Ref: A/30/20/PL

Proposal: Demolition of existing building and erection of a 2 bedroom bungalow with associated parking and landscaping

Location: Land rear of 1 The Heathers Arundel Road Angmering BN16 4LE.

We object to the planning application because:

Proposed Bungalow Plans and Elevations

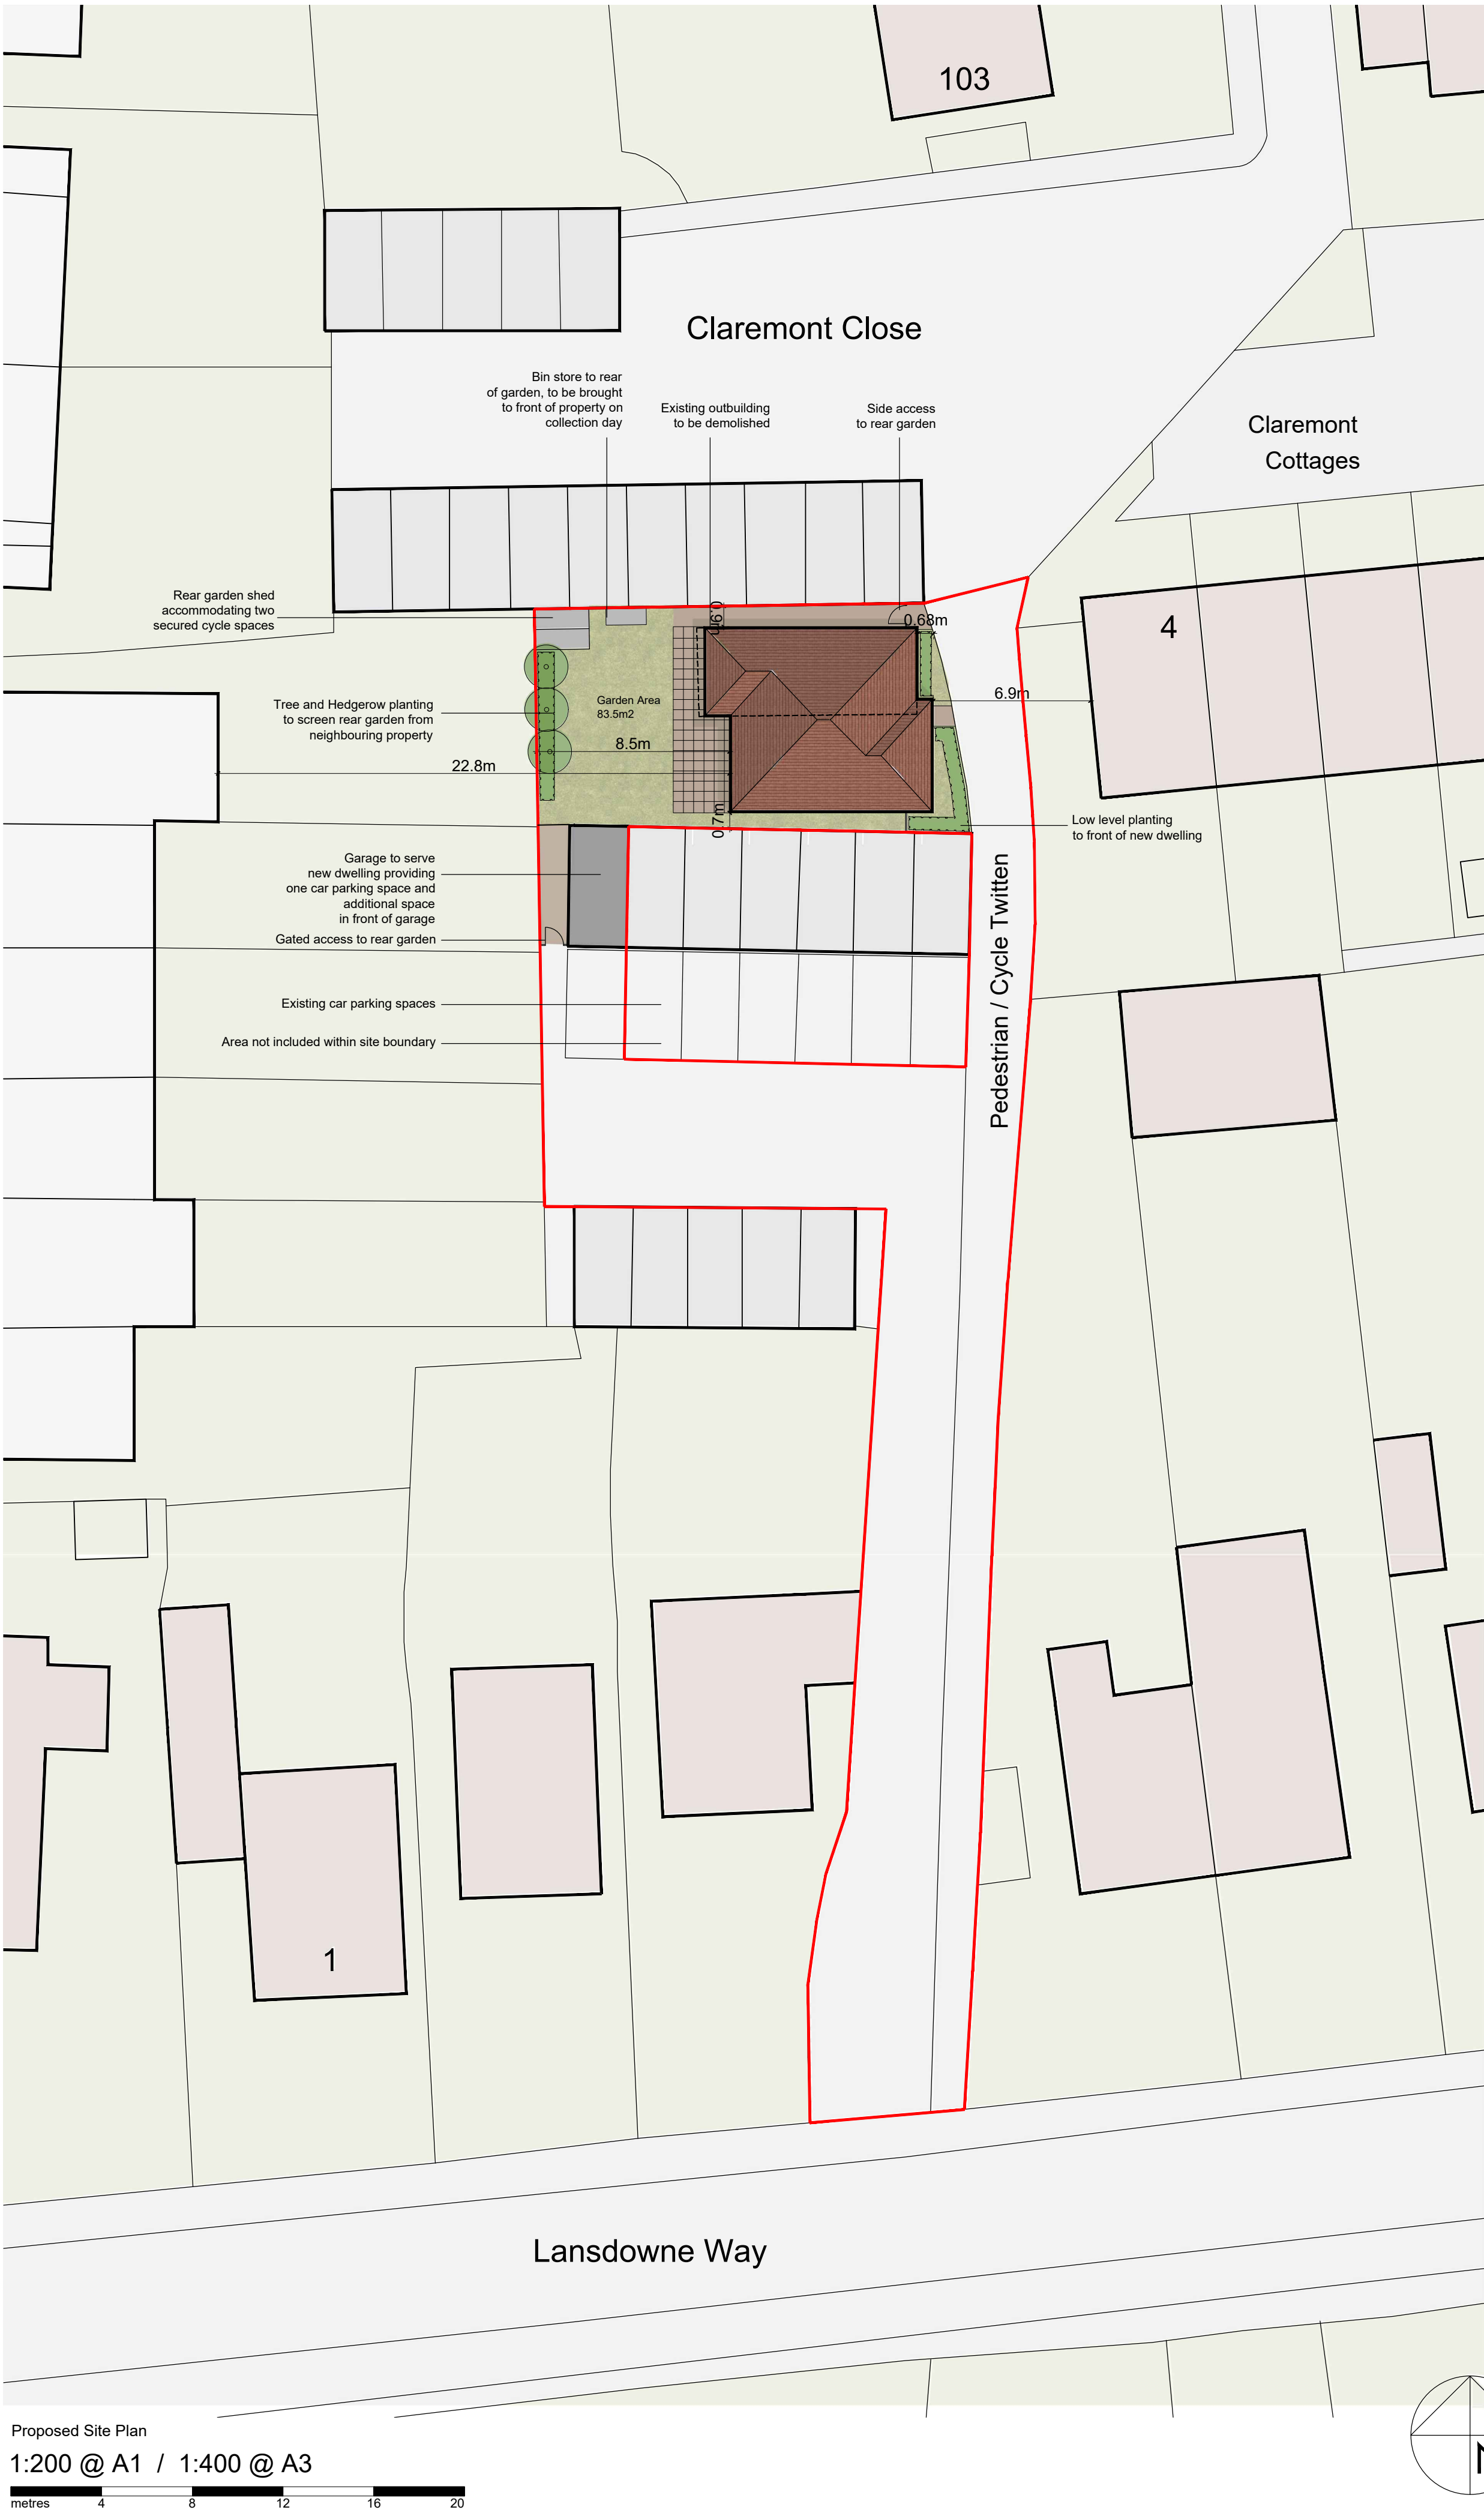
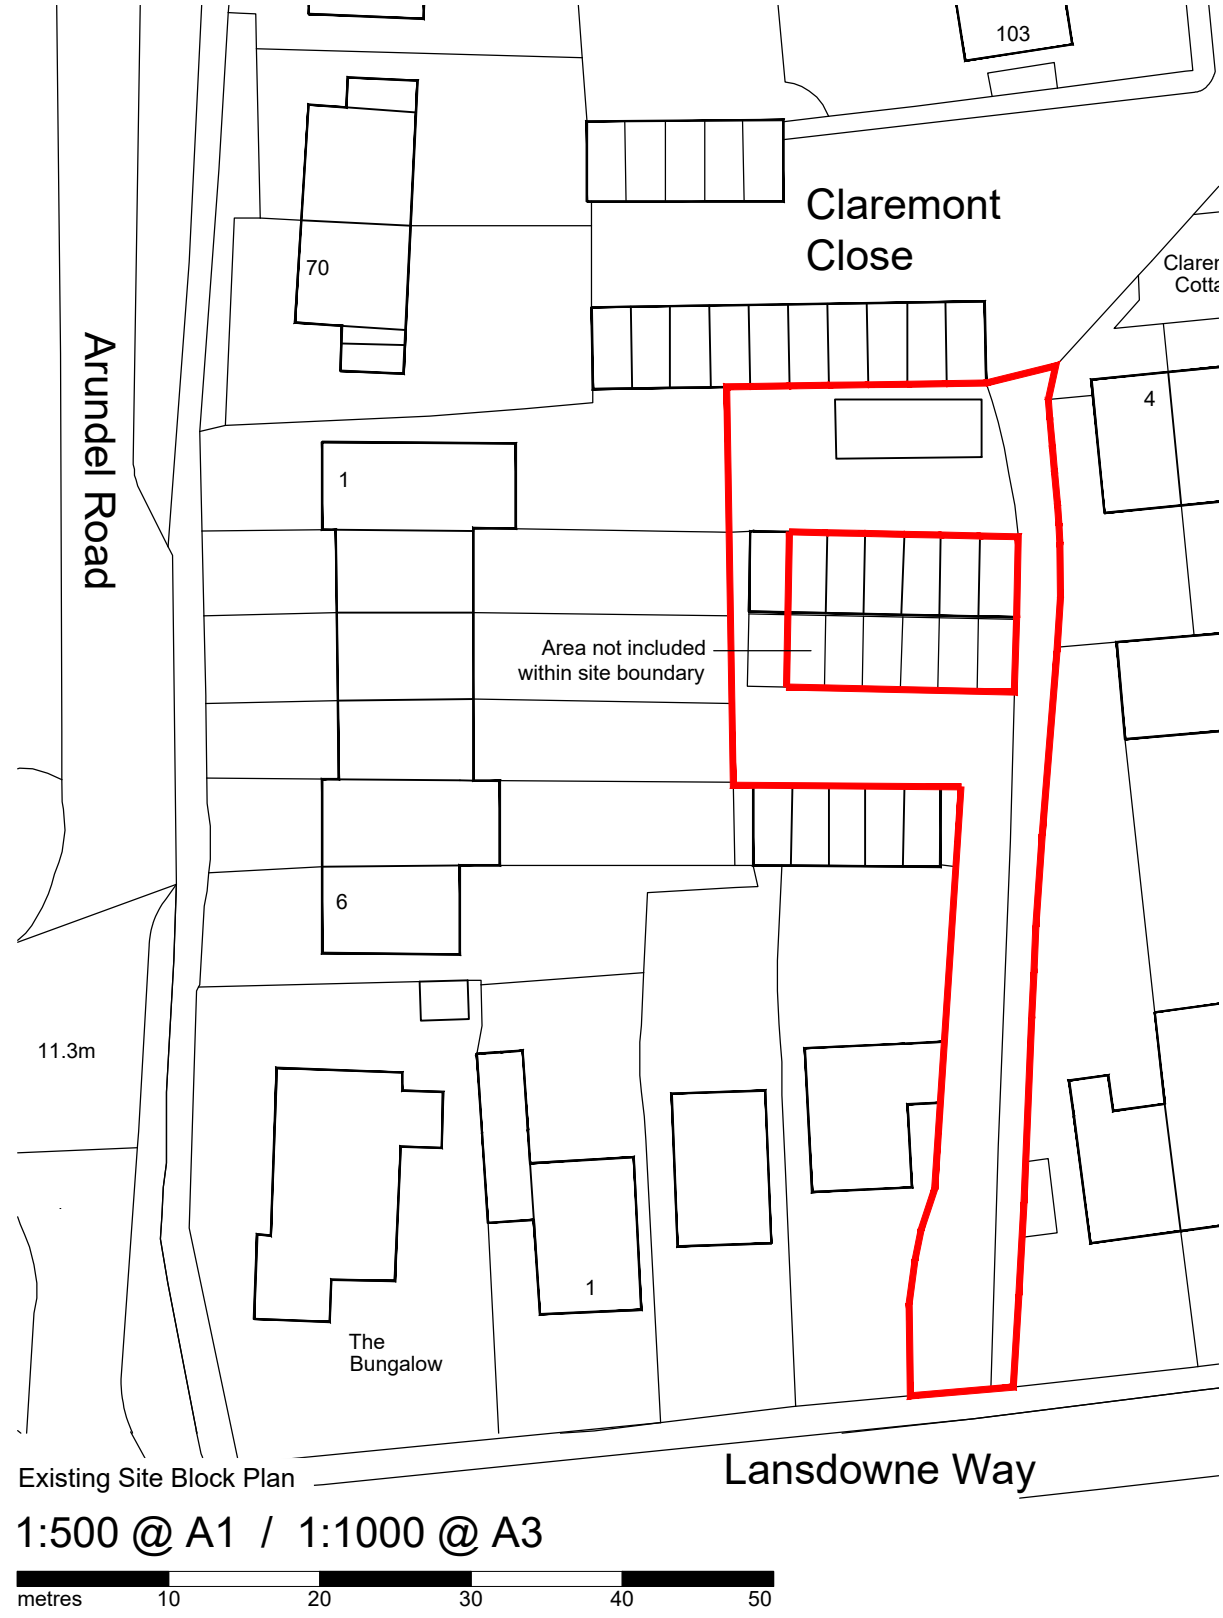
The proposed two bedroom bungalow is too large for the site area (0.02 hectares). The proposed footprint shows significant increase from the existing outbuilding which is only a small single storey store and already dominates the site. Therefore, scale and massing is not appropriate for the setting and site.

There are no finished floor levels (FFLs), eaves or ridge heights shown on the proposed drawings. Proposed heights in relation to existing neighbouring properties need to be shown in order for residents to understand the scale of the proposal in relation it is context. Please can this be provided as soon as possible.

The concern here is that the site slopes upwards and is approximately 1.5m plus higher than the properties of no. 1-6 The Heathers. This exacerbates the overlooking concerns from ground floor within the property. This will definitely mean existing habitable rooms on The Heathers are overlooked at ground floor level. This will include a bedroom which is proposed to have floor to ceiling glass.

The floor to ceiling glazing on the east elevation may overlook habitable rooms along existing properties in Arundel Road (in particular no. 70, to 1-6 The Heathers). This design of glazing is not a sensitive response to existing properties and from our first

floor windows we will be able to see into the proposed bungalow's living room and bedroom . At night time this glazing will emit light further disturbing existing residents.

The distances shown to neighbouring properties only shows the furthest away points. Worst case scenarios (closest distances) should be shown as this is misleading.

The garden appear too small and the area given presumably takes into account all surrounding paths and front garden, which shows the useable garden area is significantly less.
